Include GEC Checklist in next submittal:

GRADING AND EROSION CONTROL PLAN CHECKLIST

HORZ. SCALE: 1"=20'
 VERT. SCALE: N/A
 SURVEYED: N/A
 CREATED: 3/20/20
 PROJECT NO: 090001
 SHEET: C1.1

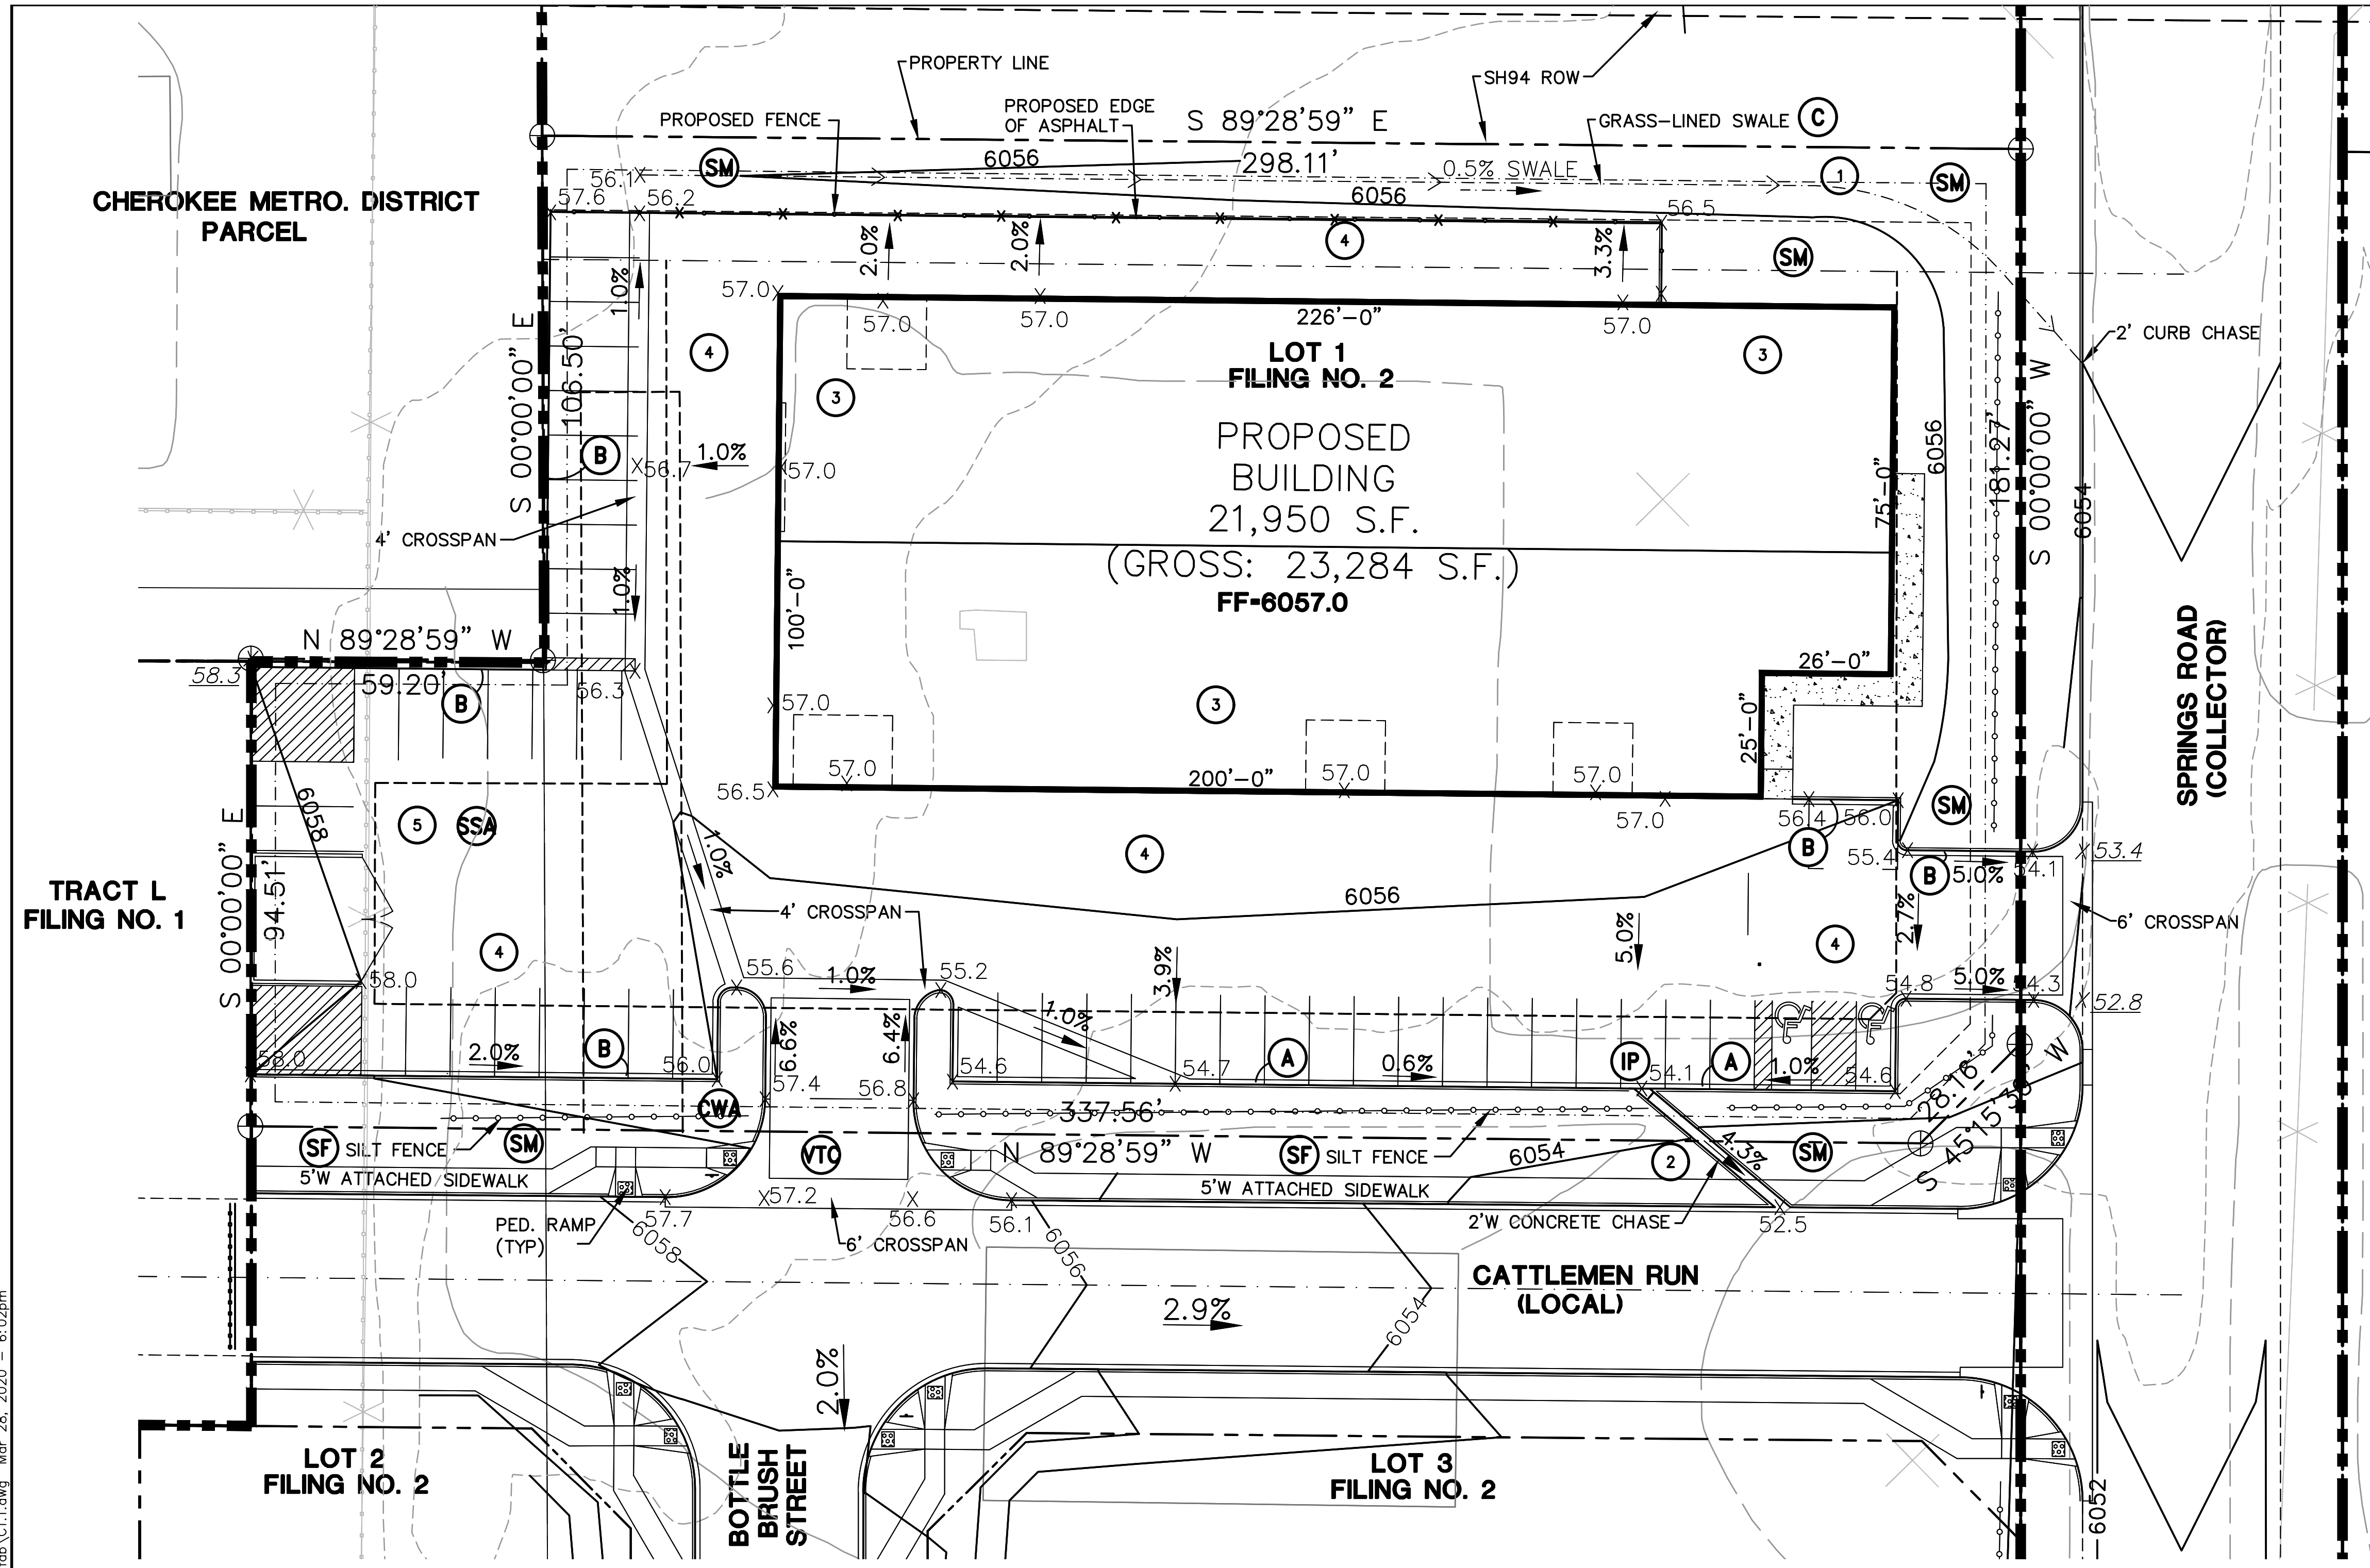
l	Existing and proposed contours 2 feet or less (except for hillside).		✓
m	Limits of disturbance delineating all anticipated areas of soil disturbance.		X
n	Identify and protect areas outside of the construction site boundary with existing fencing, construction fencing or other methods as appropriate.		X
o	Offsite grading clearly shown and called out.		N/A
p	Areas of cut and fill identified.		X
q	Conclusions from soils/geotechnical report and geologic hazards report incorporated in grading design (slopes, embankments, materials, mitigation, etc.)		✓
r	Proposed slopes steeper than 3:1 with top and toe of slope delineated. Erosion control blanketing or other protective covering required.		N/A
s	Stormwater flow direction arrows.		✓
t	Location of any dedicated asphalt / concrete batch plants.		N/A
u	Areas used for staging, storage of building materials, soils (stockpiles) or wastes. The use of construction office trailers requires PCD permitting.		✓

v	All proposed temporary construction control measures, structural and non-structural. Temporary construction control measures shall be identified by phase of implementation to include "initial," "interim," and "final" or shown on separate phased maps identifying each phase.		X
w	Vehicle tracking provided at all construction entrances/exits. Construction fencing, barricades, and/or signage provided at access points not to be used for construction.		X
x	Temporary sediment ponds provided for disturbed drainage areas greater than 1 acre.		X
y	Dewatering operations to include locations of diversion, pump and discharge(s) as anticipated at time of design.		N/A
z	All proposed temporary construction control measure details. Custom or other jurisdiction's details used must meet or exceed EPC standards.		✓
